Development Control
Ribble Valley Borough Council

Re: Planning Application 19/0894

Address: Pendle View Primrose Lane Mellor BB2 7EQ

Description: Change of use of agricultural land for the siting of 12 holiday lodges, associated site office/reception and car parking area.

Proposed Site Plan with Topographical Data -
1:500

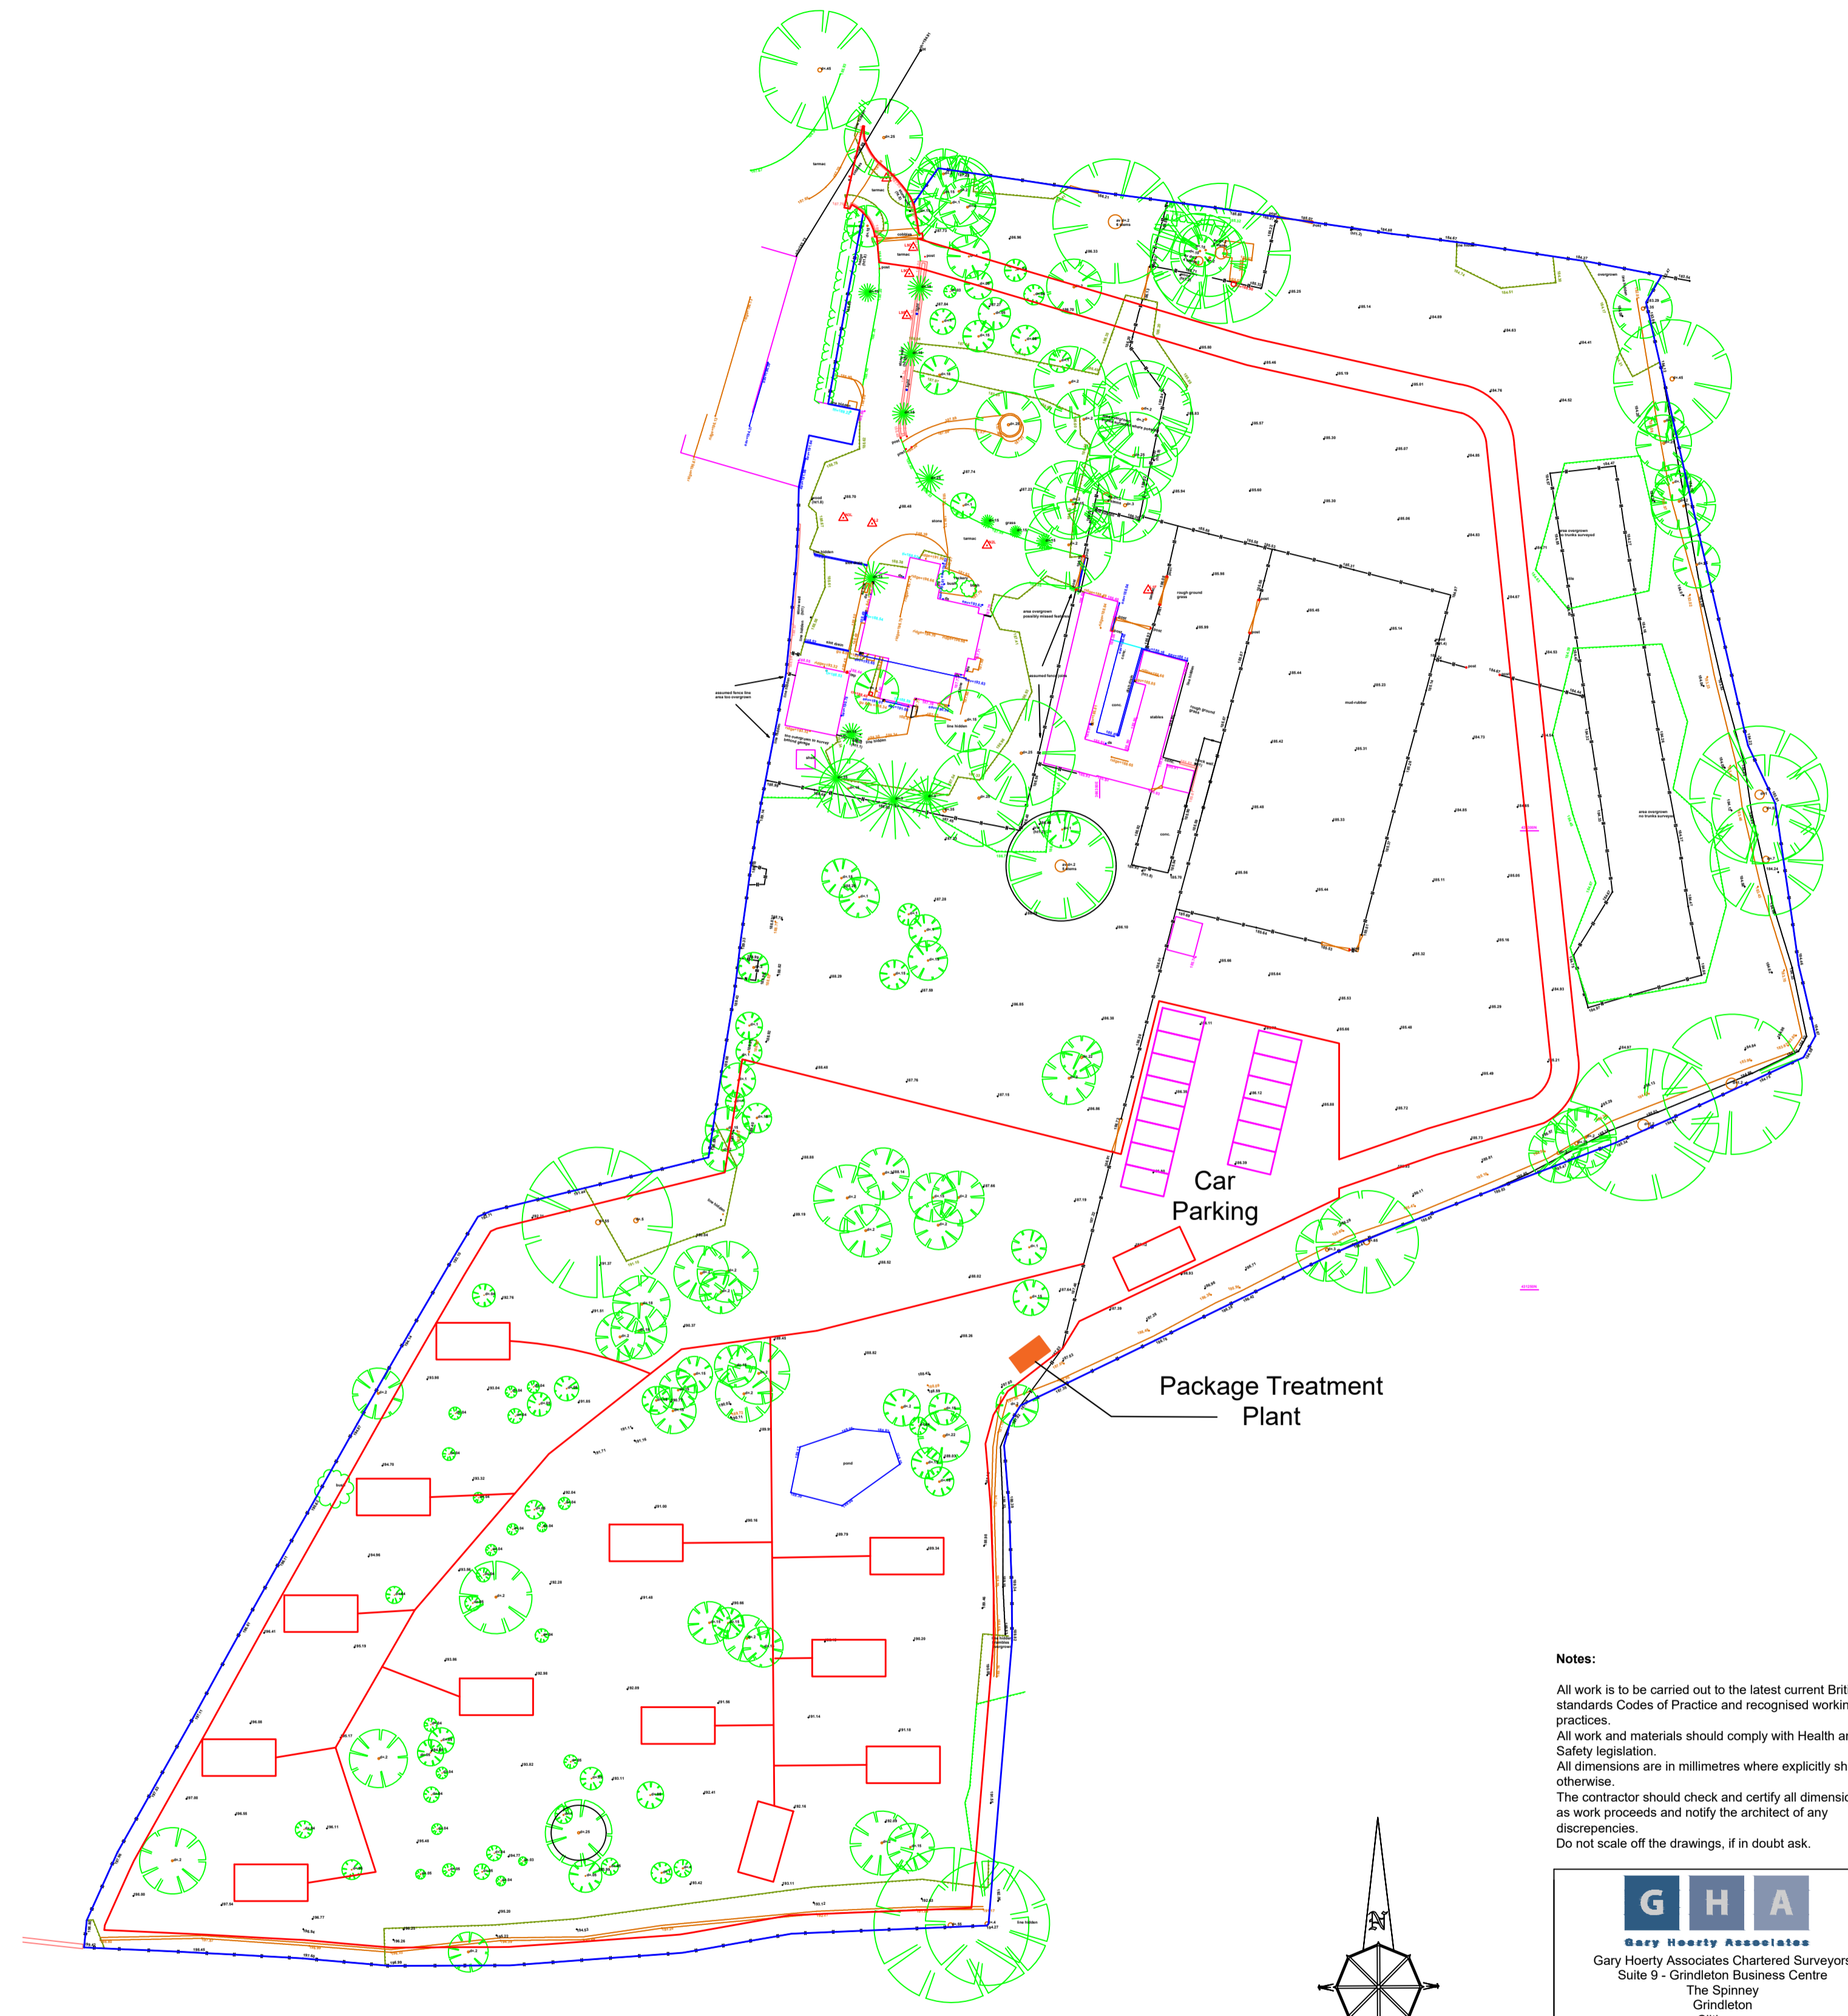
The concerns regarding the access are that there is insufficient space to allow two vehicles to pass at the entrance to the site at the same time. This could lead to vehicles having to wait on Primrose Lane which is effectively a single track lane.

In order to progress the application we would look for a plan showing how the access to the site can be improved in order to allow two vehicles to enter and exit independently of each other, it is inspected that this would not be part of the entrance to the dwelling. Any gates associated with the access should either side or open away from the highway.

1. Before the access is used for vehicular purposes, any gateposts erected at the access shall be positioned 5m behind the edge of the carriageway. The gates shall open away from the highway. **Reasons:** To permit vehicles to pull clear of the carriageway when entering and exiting the site and to ensure the swing of the gates do not affect the availability for a car to wait off road.
